**Application no: 22/00593/DISC**

**Location:** Heyford Park, Camp Road, Heyford Park, Bicester, OX25 5HD

## **Transport Development Control**

#### **Condition 5 Accesses, driveways and turning areas**

TYPICAL MANHOLE DETAIL TYPE 2

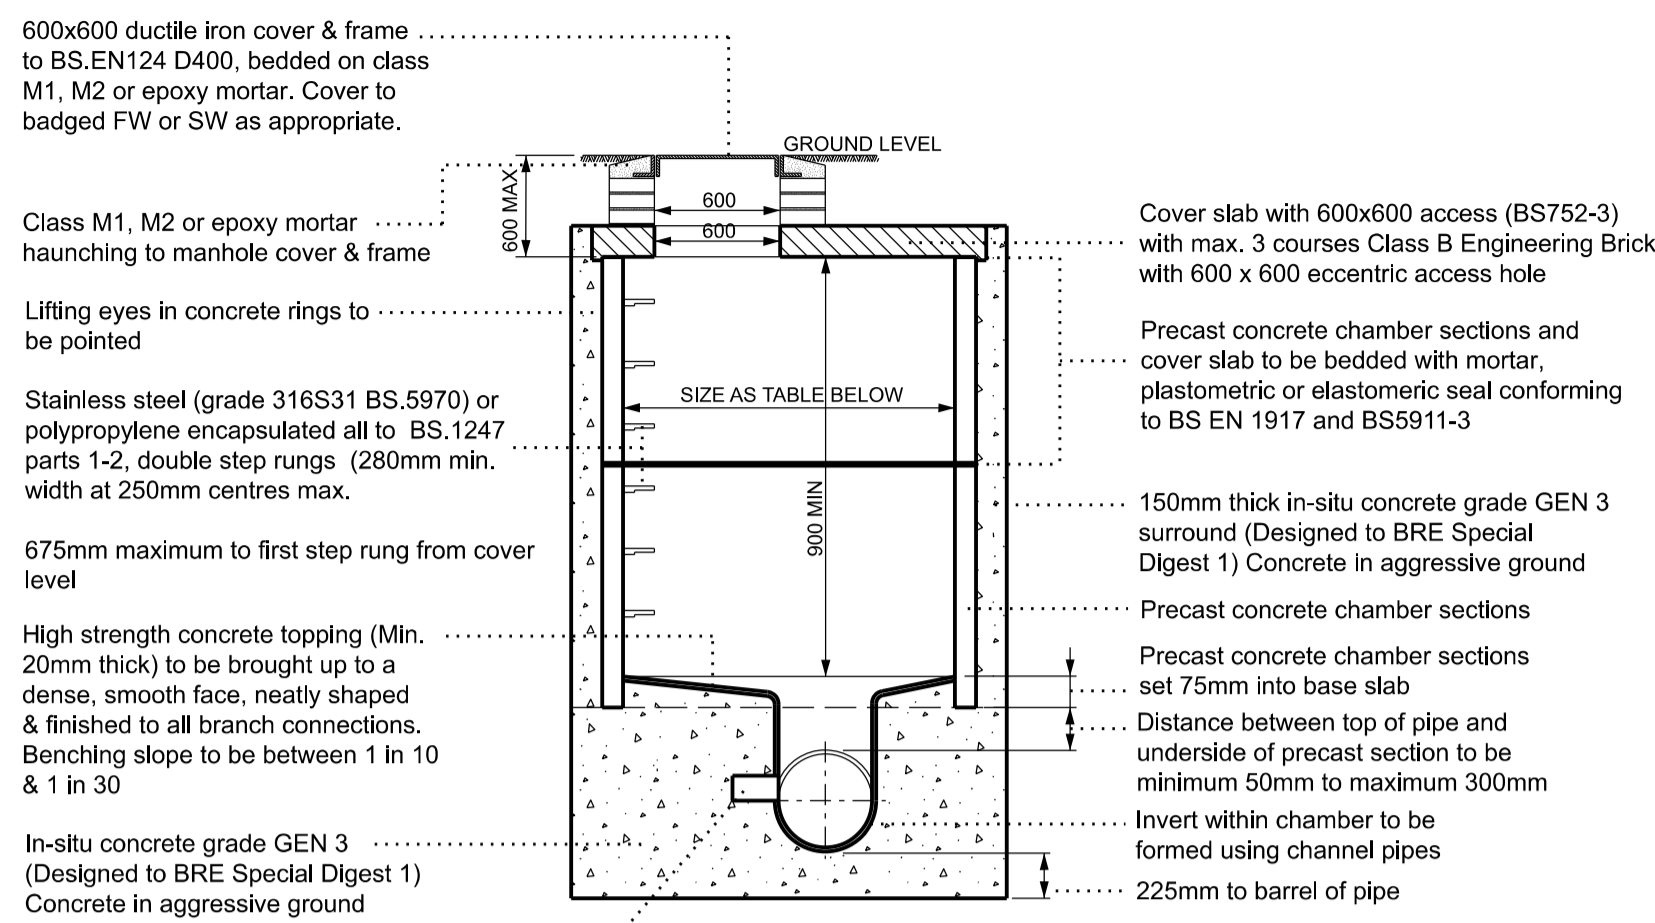
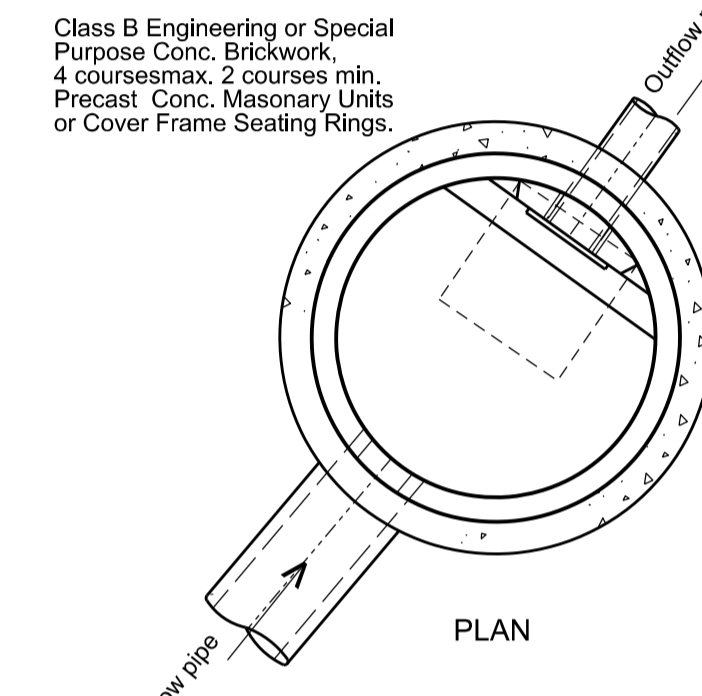
- Over-run strip possibly not needed and wider footway could be provided instead.
- The drawings specify manholes as opposed to catch pits, but this will be a Thames Water adopted sewer so this may not be an issue.
- A couple of trees will require tree pits and commuted sums.
